**ANGEL PLACE
LEVEL 8, 123 PITT STREET
SYDNEY NSW 2000**

SSD-10454 | INTERCONTINENTAL HOTEL - STAGE 2 | RESPONSE TO SUBMISSIONS

1 LEVEL 32 FACADE ELEVATION - EAST
SCALE 1 : 100

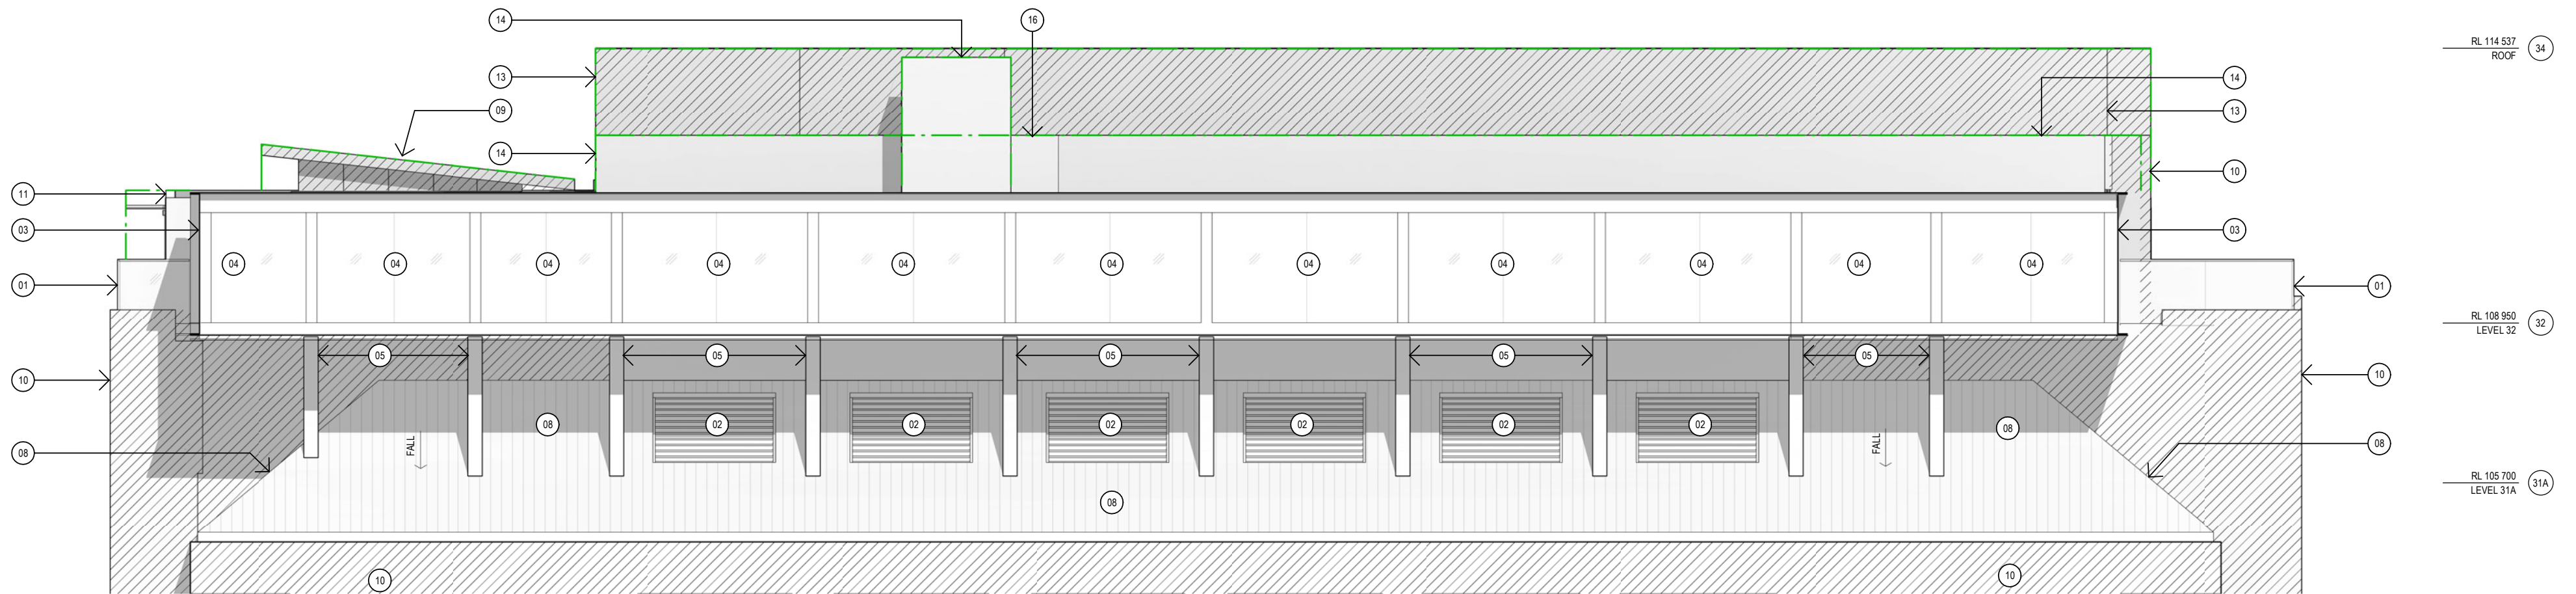
Comment	Response
<p>8. While the proposal includes minimal new reflective glass, there is an opportunity for the addition to include a treatment or finish of glass that will reduce the likelihood of bird strikes. This can either be placing glass behind some type of screening or using glass with inherent properties that reduce collisions. Generally options include but are not limited to:</p> <ul style="list-style-type: none"> • Installing opaque glass or etched, stained, frosted glass and glass blocks. • Angled glass (popular in Europe and Asia), although reflectivity effects are more pronounced and require careful consideration. • Awning hoods and overhangs over windows to reduce reflectivity. • Patterns on glass (ceramic dots, “frits” with a specific 2 x 4 design). • Screens, shutters, exterior shades. <p>Ideally, the City recommends that all reflective glass within the development include treatments as the reflection of sky and/or vegetation increases the risk of impact as there is a clear line of sight.</p>	<p>We have undertaken due diligence / analysis on this matter using Birdlife Australia's 'Birds in Backyard Program' and do not consider the incorporation of specific glazing treatments (to mitigate bird strike) necessary for this project.</p> <p>Birdlife Australia outline a series of characteristics that place building features and facades ‘at risk’ of bird strike. These are summarised below in italic text:</p> <ul style="list-style-type: none"> • <i>Buildings with large areas of uninterrupted glass. (more than 80% glass coverage).</i> • <i>Transparent glazing which would allow clear views through to the other side of the building.</i> • <i>Glazing and/or surfaces that reflect sky or vegetation may be confused as an available flight path or habitat.</i> • <i>Landscaping features, such as resource-rich or fruit bearing trees, plants and water features bring birds closer to windows and increase the risk of collision.</i> • <i>Buildings close to abundant urban greenspaces with complex vegetation are hotspots for window collisions.</i> • <i>Abundant interior greenery which is visible from the outside of the building.</i> <p>While we note Council have recorded instances of birds striking CBD buildings, we do not believe the Intercontinental Hotel (which is characterised by heavy concrete facades, punctuated by half height windows) is an ‘at risk’ building using the criteria noted above.</p> <p>It is noteworthy that the Level 32 extension is located high above the ground level and will not reflect vegetation or sky.</p>

Comment	Response
	<p>Applying the principle of reasonableness and noting that the primary design objective of the Level 32 extension is to maximise uninterrupted views toward Sydney Harbour and the city skyline, the proposed glazing solution is considered appropriate for the development.</p>
<p>9. It is also noted that the architectural drawings show a 1m high balustrade along the terrace, however, the submitted wind report recommends a 1.4m high balustrade. It is recommended that the architectural drawings include this design change.</p>	<p>Upon re-checking the drawings, Woods Bagot have confirmed that the balustrade height measures 1.3m. The contention from Council that the balustrade height is 1m may be because the floor level is actually lower than where the glass element of the balustrade ends and the precast concrete upstand continues. For avoidance of doubt, a dimension has been added to the Woods Bagot drawings (Appendix D).</p> <p>It is noted that the submitted wind report mistakenly required a 1.4m balustrade. This has been corrected in a revision (Appendix E), which confirms that wind impacts can be successfully ameliorated through a 1.3m high balustrade.</p>

SETBACK DIAGRAM | VIEW FROM SOUTH-WEST

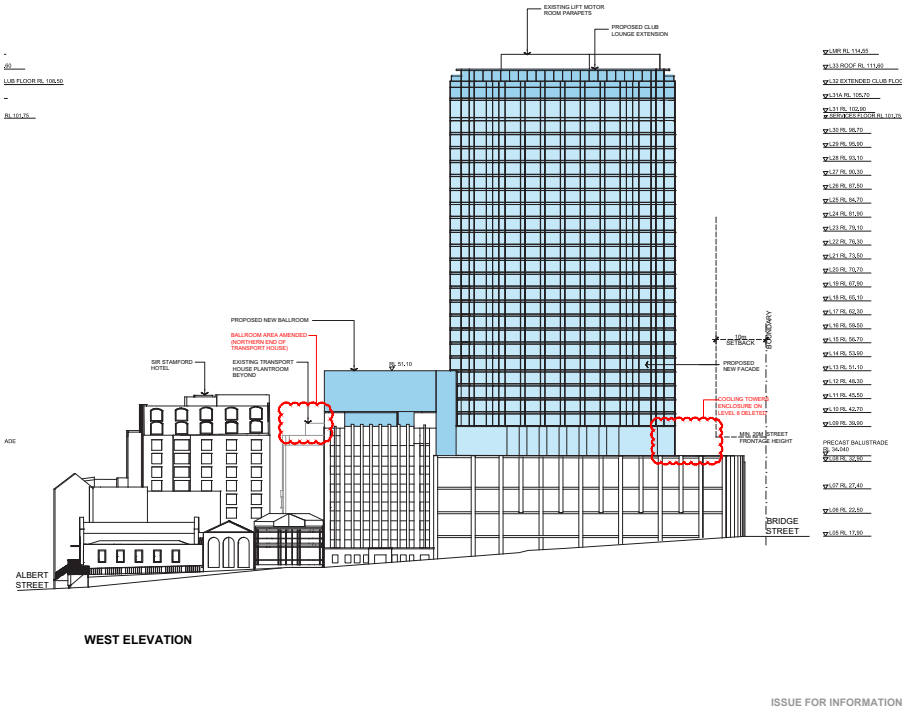
Comment	Response
	<p>Because of the upgrade works, it is expected that the bar spaces will be used at (or near) capacity more frequently. Because of this, hotel management have nominally estimated that up to 50 additional staff will be required to service the hotel.</p>
<p>4. further details of the proposed replacement plant and an assessment of impacts.</p>	<p>Woods Bagot have prepared a drawing (Appendix B) which confirms:</p> <ul style="list-style-type: none"> ▪ Existing FDU ductwork will be retained. ▪ Existing kitchen dishwasher hood to be replaced with two similar fans and relocated slightly northward to suit new kitchen layout. This hood is excluded from the calculation of building height under the standard template LEP definition and therefore, this relocation does not trigger a height or Stage 1 envelope non-compliance. ▪ Existing toilet exhaust fan to be retained or replaced on a like-for-like basis (to be confirmed at CC stage).
